Re
FP/195/18/PL
Mr. M. ISITT.

I am writing to object to the resubmission of plans FP/127/17/PL

EXISTING STREET ELEVATION

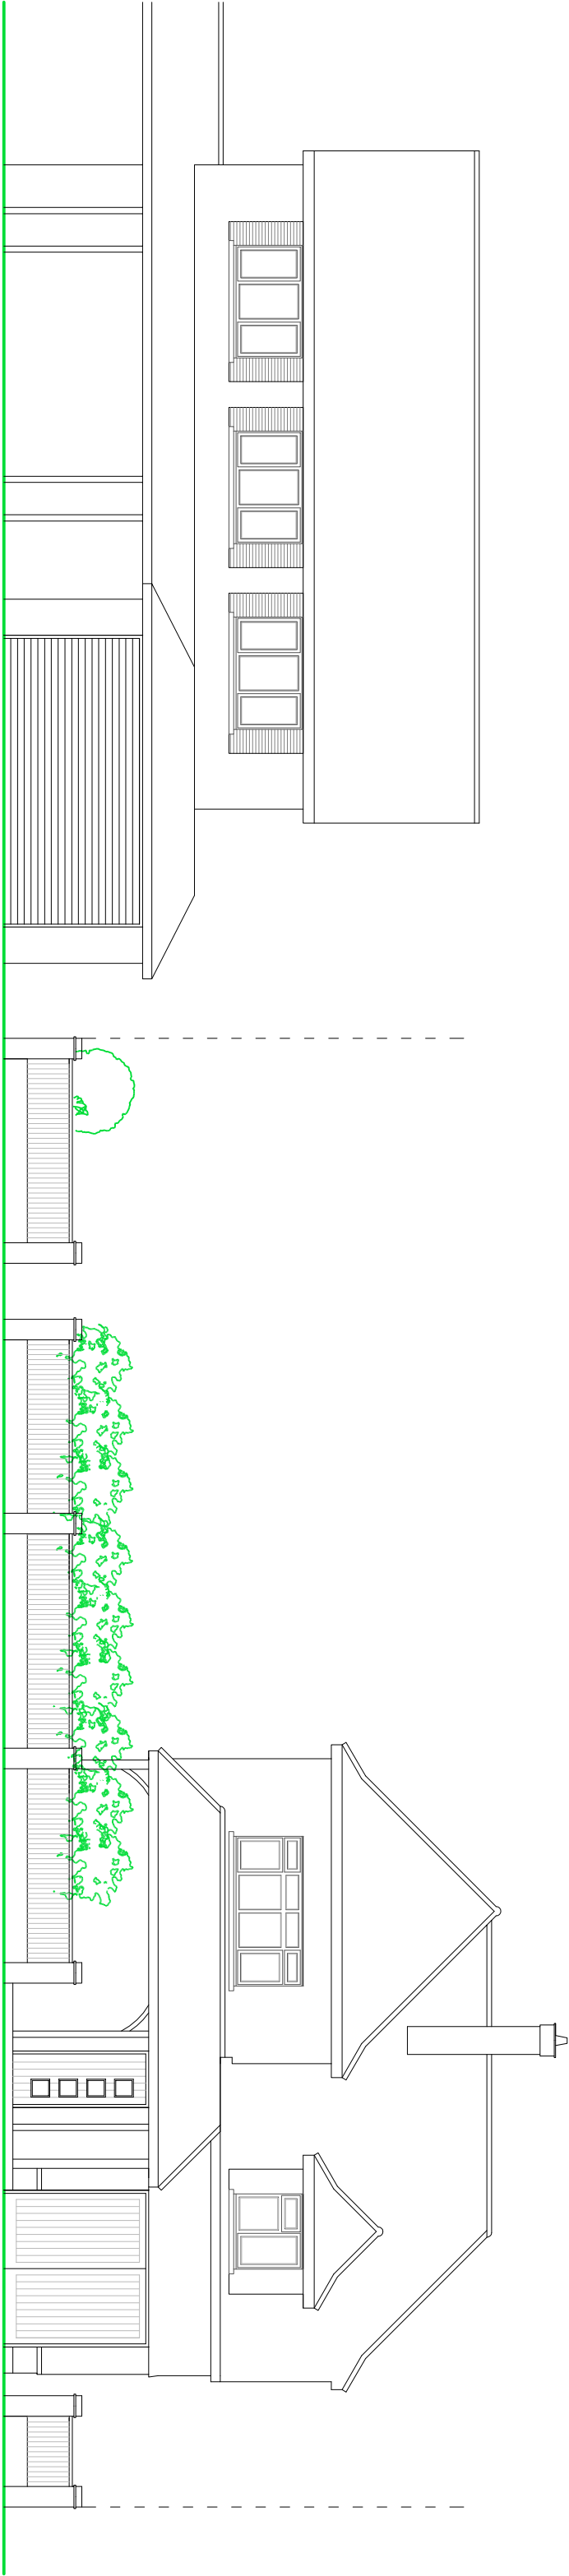
The plans submitted were not correct. The previous owners of our property (No 1) made additions to the front + back elevations which resulted in a very narrow pathway (1 metre).

## PROPOSED STREET ELEVATION

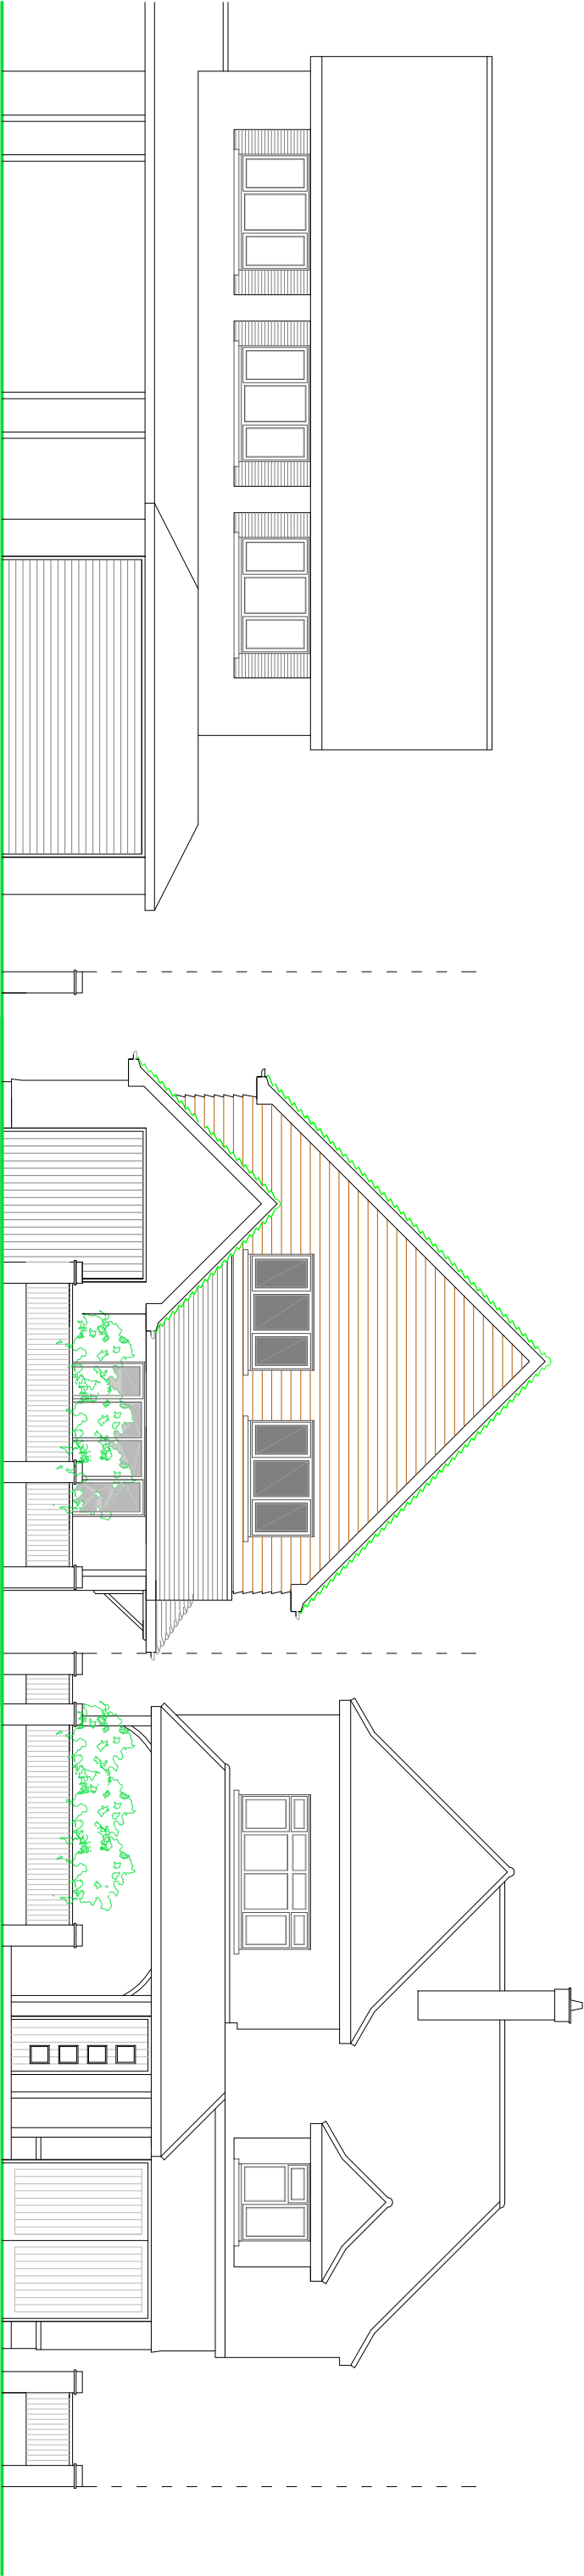
The proposed new dwelling will be very intrusive and loom over us, destroying and sense of space, light + privacy. We have already had the bungalow at the back of their garden only (1 metre space) which is fully occupied by Mr Michael Jackson, and is fully fenced from Mr Isitt's garden. This has been very intrusive already.

The proposal for the new building will have a very tight narrow appearance in the road.
